An Taisce

20240424-ABP-319217

For: Application for substitute consent for quarry

Site: Philipstown and Redbog, Co. Kildare

Figure 2-8 - Dust Monitoring Locations

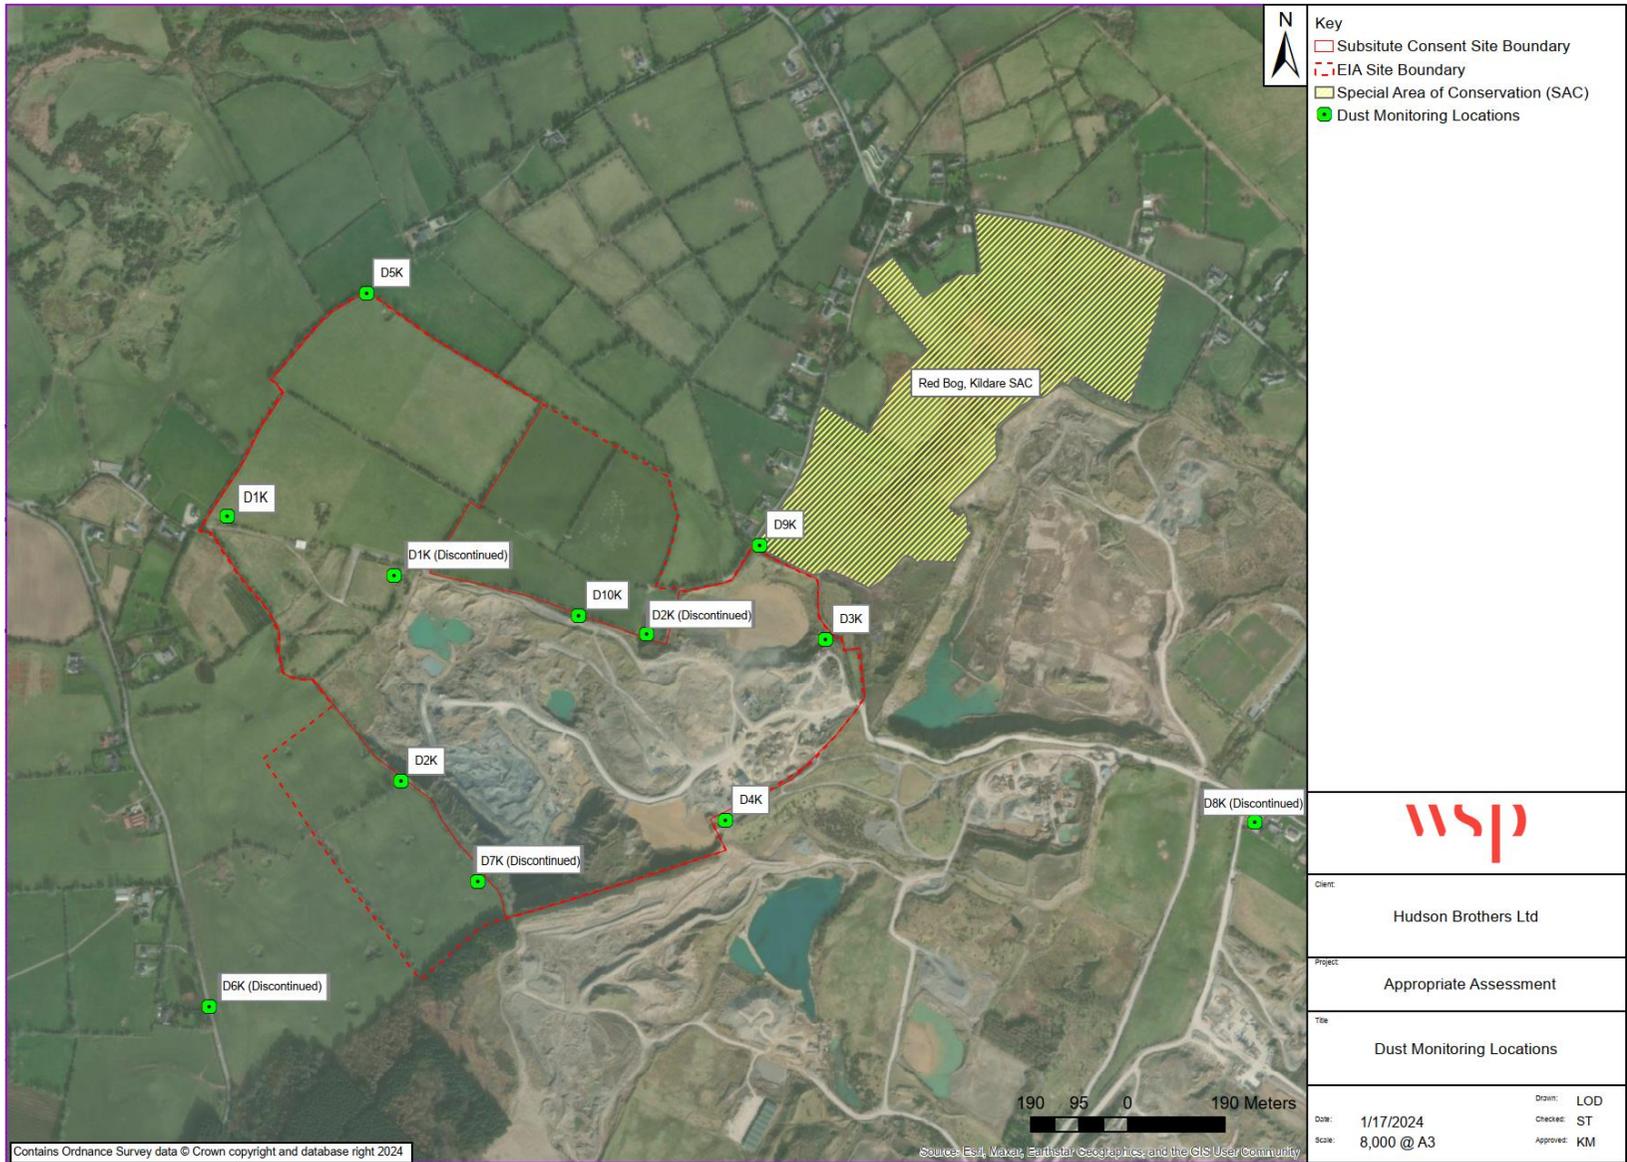
We note that the maximum recorded emission of dust was 698 mg/m² /day from D3K, which equates to 0.698 g/m²/day. Mean dust emissions were 190 and 119 mg/m² /day, equating to 0.19 and 0.119 g/m²/day. The studies which the applicant relies on to reach the conclusion of no impact actually highlight that impacts from dust on sphagnum could be detected at just 0.07 g/m²/day (Spatt & Miller (1981) cited in Farmer (1993)). Additionally, the IAQM outline that the distance these can travel is up to 500 metres, as outlined above. Yet in section 5.4.4 the applicant outlines that: *"in accordance with Table 5-1, dust impacts are considered up to a distance of 50 m from the boundary of Red Bog SAC."*

Figure 5-2 - Dust Emissions at D3K and D9K (August 2020-October 2023)

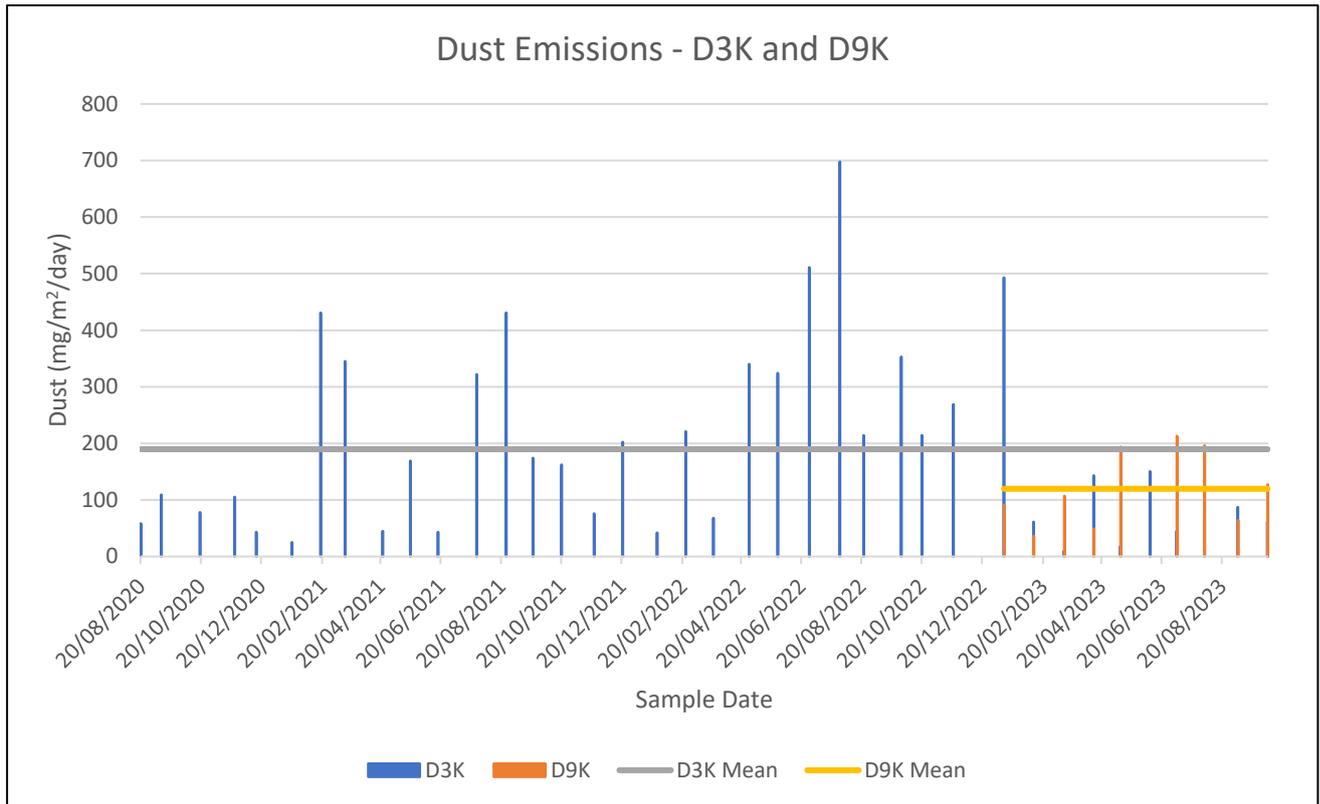
Table 5.1 is the IAQM study looking at demolition dust, while the IAQM study looking at quarrying dust indicates are far higher distance of impact. We submit that limiting the consideration to only 50 metres from the boundary of Red Bog SAC is flawed, and is not based on best available science.

As such, we strongly submit that the issue of dust emission warrants further assessment in a Stage 2 rNIS. The mean and maximum levels have been previously demonstrated in peer reviewed studies to have a negative impact on sphagnum moss, which is the primary vegetation in the Red Bog SAC, and the SAC is well within the impact zone previously established for quarry dust. We submit that the findings of previous studies clearly indicate that there is reasonable scientific doubt in regard to the potential impact of dust on a European protected site, and in our view screening it out is premature and erroneous.
